APPENDIX 11. AIR QUALITY - RESPONSE TO EIS

The following review of the EIS

Figure 6-2: Dust Deposition (Insoluble Solids) Results [Hanson, 2014]

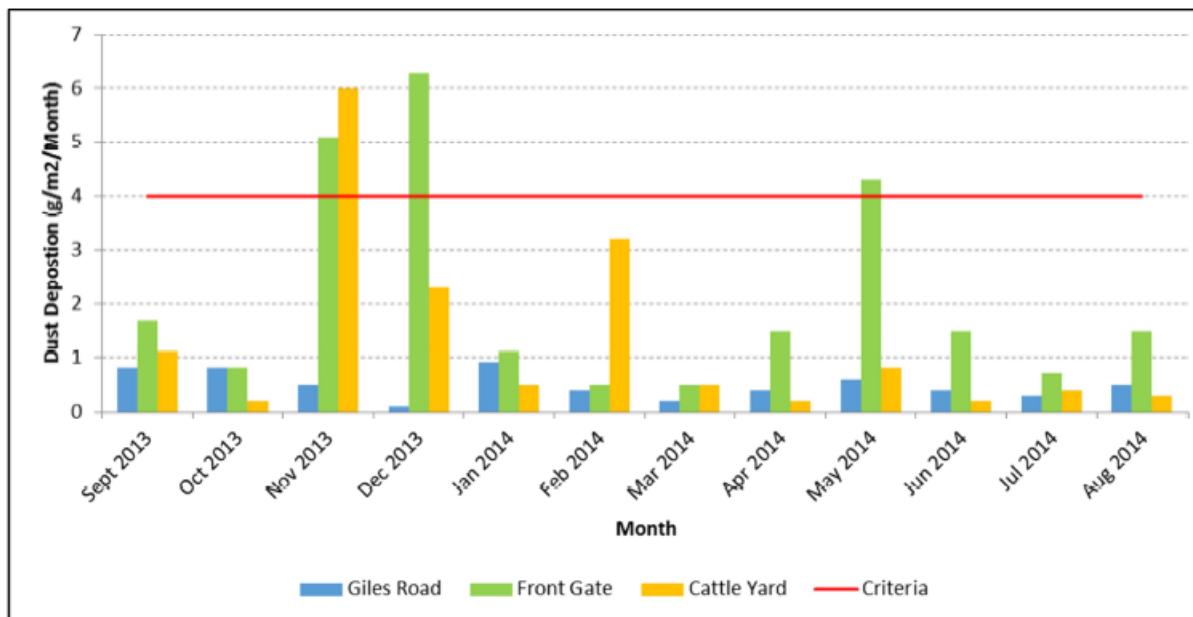
Comment: This data is not based on a calendar year like inputs into the TAPM-CALMET-CALPUFF models. The Air quality model is based on 2013 calendar year data. It is from Sept 2013 to August 2014. Every exceedance is blamed on bird droppings, no inorganic value is stated which would give a dust particulate value. There is no commentary on operational activities and weather conditions. Without these parameters and the fact that dust gauges are easily tampered with and provide a 30 day average result, the validity of the data is questionable.

Figure 7-1: Comparison of Patterson AWS Wind roses and TAPM Wind roses

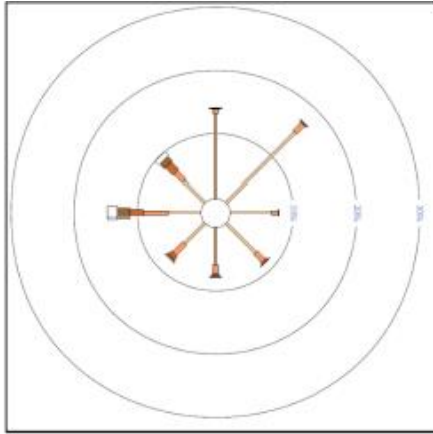
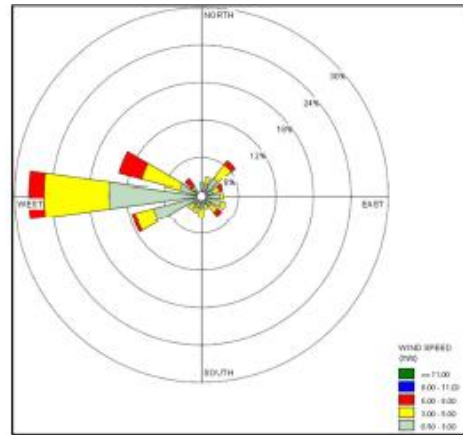
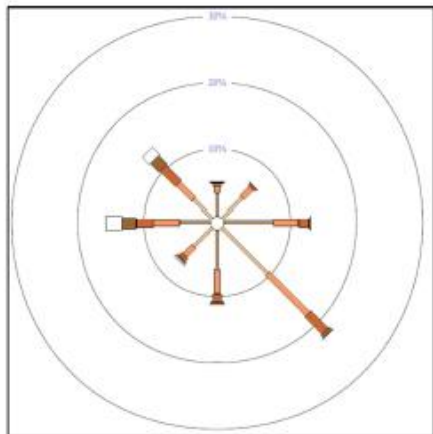
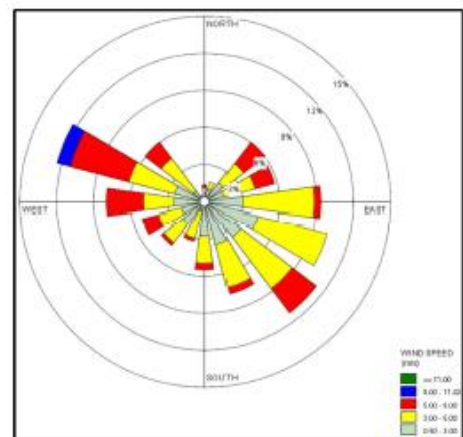
Comment: Why are these wind roses considered valid when the overall location does not align with the AWS location (Tocal). The wind rose could also not be extracted from the calmet model.

Comment: are these seasonal or annual wind roses no explanation given.
